From: Nolan, Chris <Chris.Nolan@lancashire.gov.uk>
Sent: 09 October 2017 13:57
To: Robert Major; planning
Subject: FW: D3.2017.0695 - Lower Buck Inn, Twitter Lane, Waddington
Attachments: 492-001 B.PDF

Planning Application No: 3/2017/0695

Proposal: Change of use of existing single-storey detached store, and erection of additional single storey timber building to form two letting bedrooms for use in association with the Lower Buck Inn.

Location: Lower Buck Inn Twitter Lane Waddington BB7 3HU

Ground Floor Plan

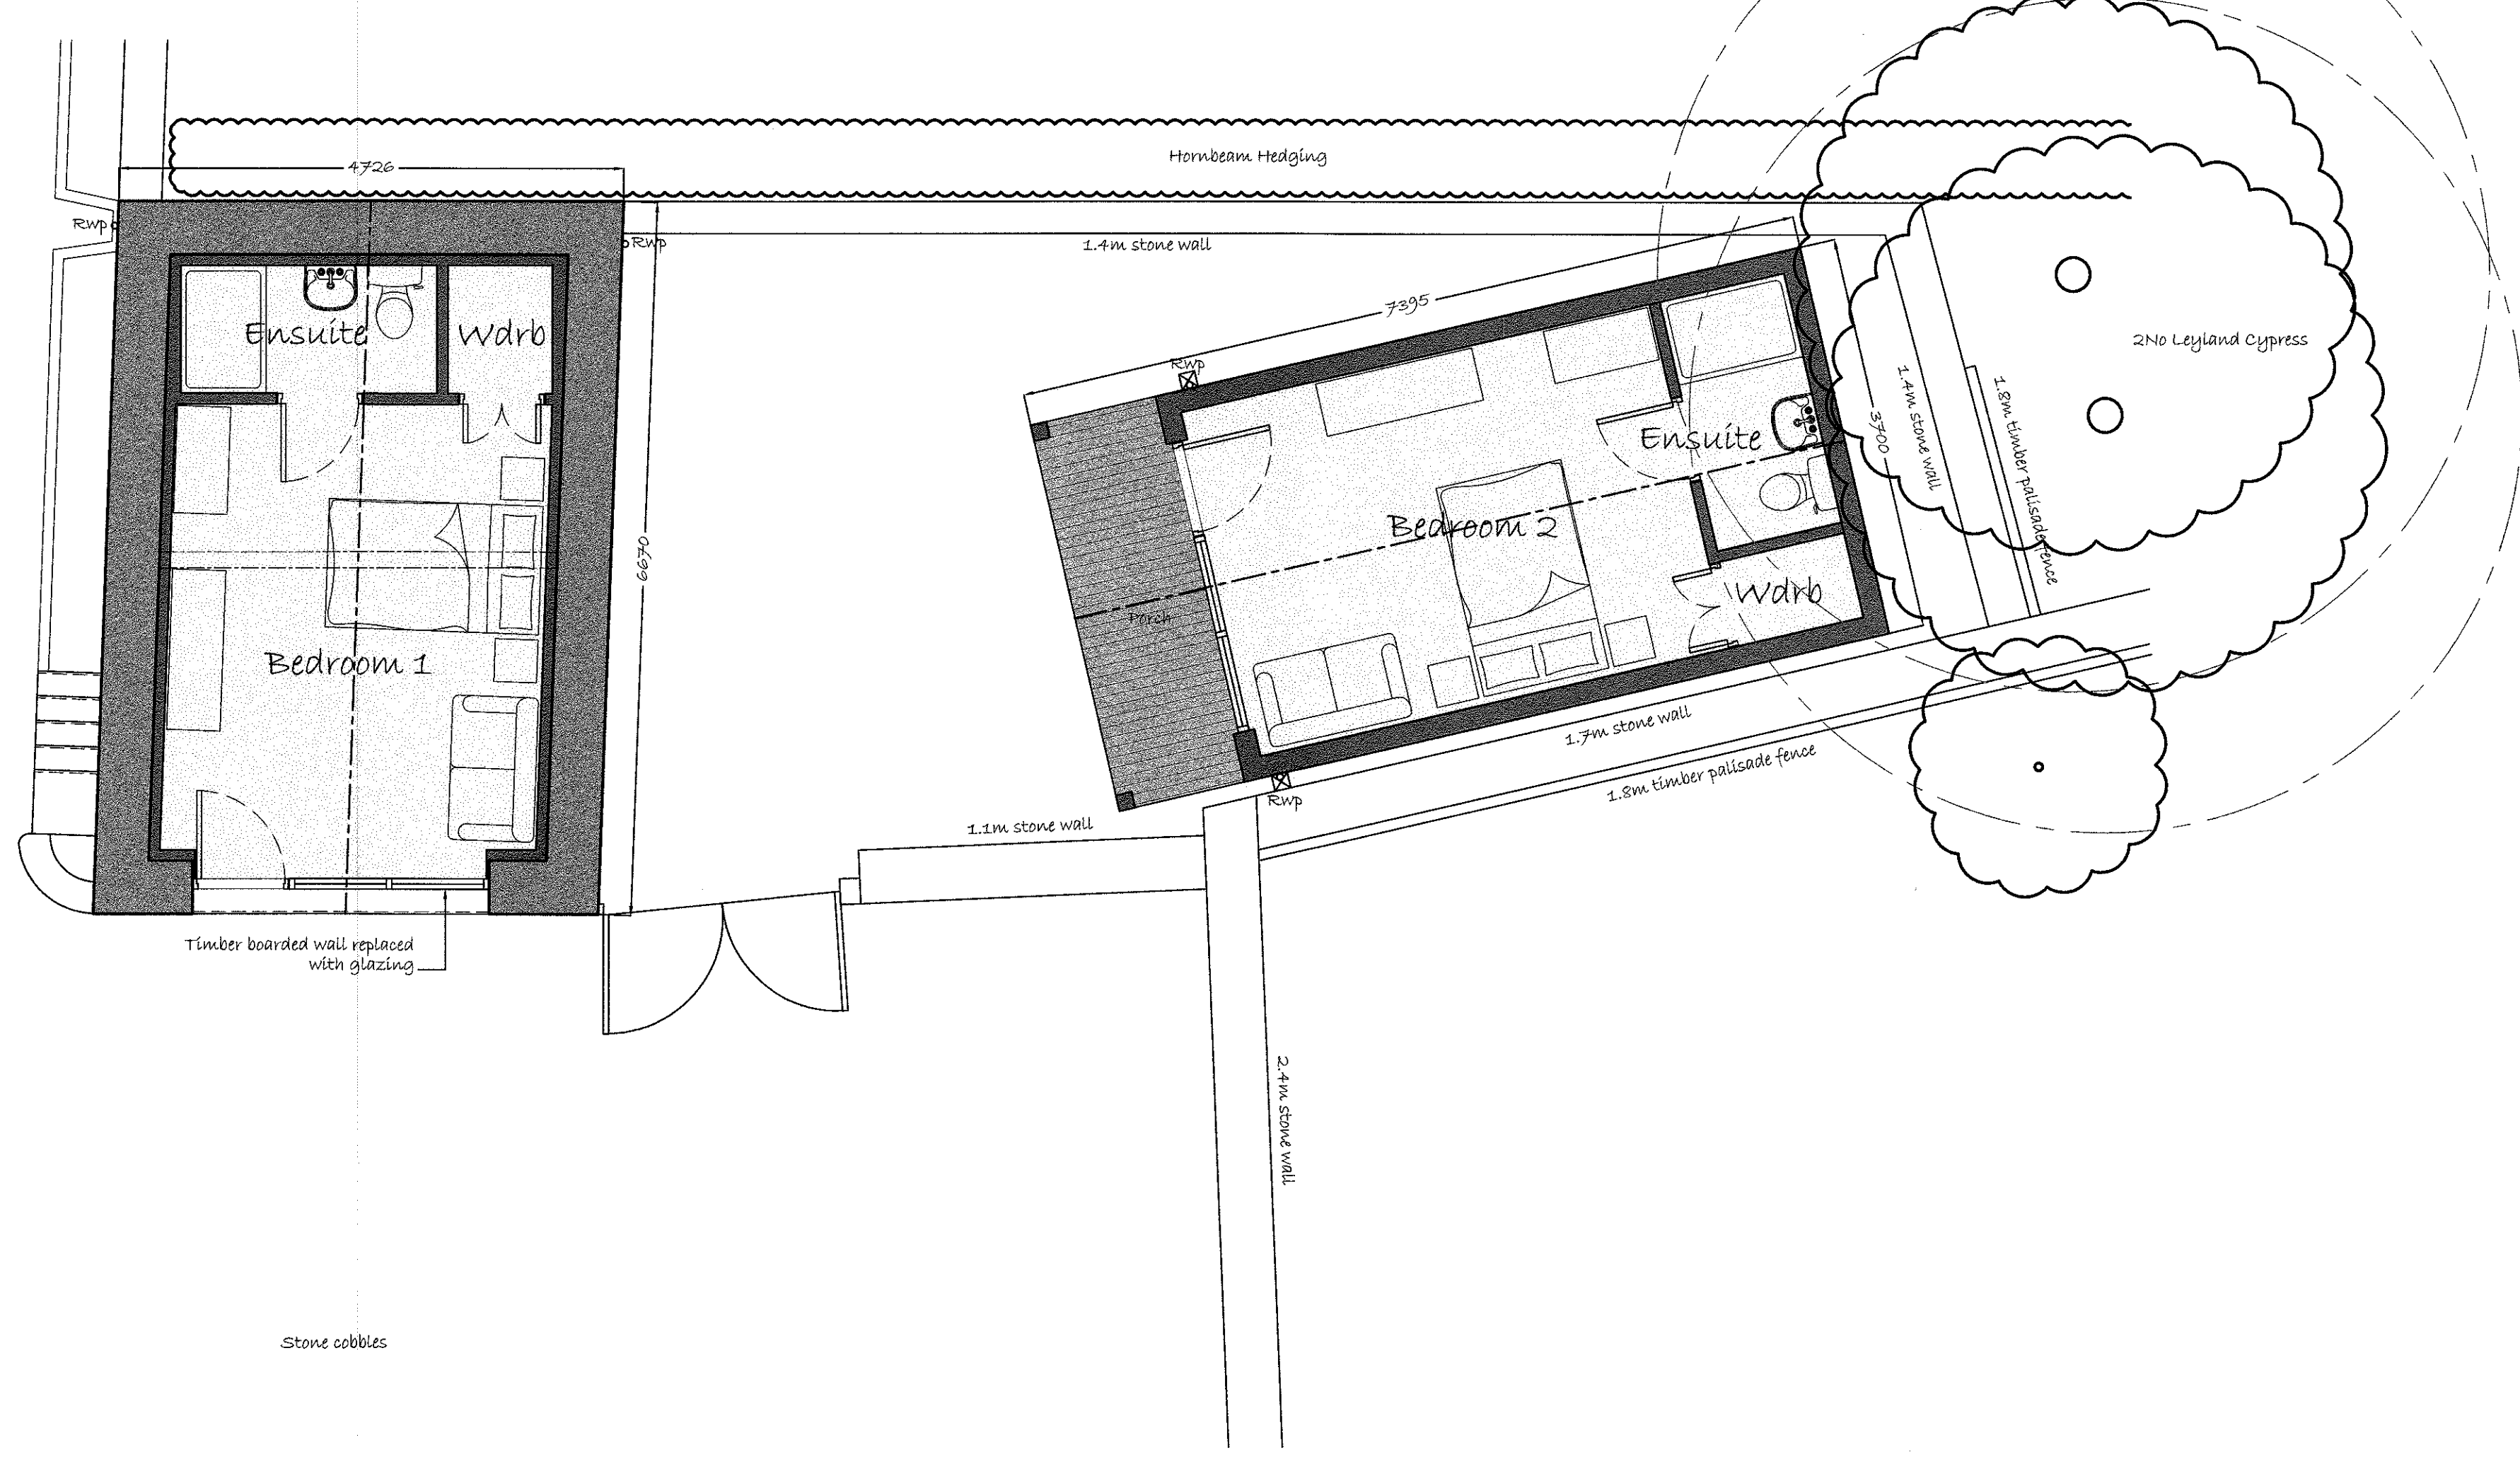
With regard to the above application. I have undertaken a site check this morning to look at overnight parking within the area and this has raised concerns with this application. Parking in Waddington can generally be described as difficult at any time but overnight this situation is exaggerated. This is true for Twitter Lane Close to the buck and confirmed by signs placed on the property indicating a drop off area and No Parking signs indicating access required at all times.

I feel that I would have to object to the application to build two new bedrooms to be let as accommodation attached to the public house unless the developer can prove that there is sufficient space available to park a vehicle per room. In addition to this I would be looking for details regarding the parking for the cottage let that is on the same site, the number of guest bedrooms there are within the public house and the parking facilities for the landlord. This information is required to ensure that the site, after this development is completed is assessed as a complete unit. I would like assurance that there is, within the curtilage of the property, sufficient

space available to meet parking standards. I would be looking for parking spaces of 5.6m long by 2.4m wide for each necessary parking space. Preferably the details would be supplied on scaled plans of a minimum scale of 1:200.

With regard to the above application, thank you for the revised proposed plans indicating the provision of two additional parking places as would be required for the additional accommodation in the former store and the additional wood cabin. As these plans indicate that the space has been made available I would now remove my objection to the development but I would ask for the following notes and conditions to be added to any permissions that your council is minded to grant.

1. The agreed parking spaces as indicated on the revised plan should be made available for use by paying guests prior to either of the new rooms being let and the additional parking should be retained for such period that the additional accommodation is available to let. Reason: The parking places are required as paying parking for any guests using the rooms
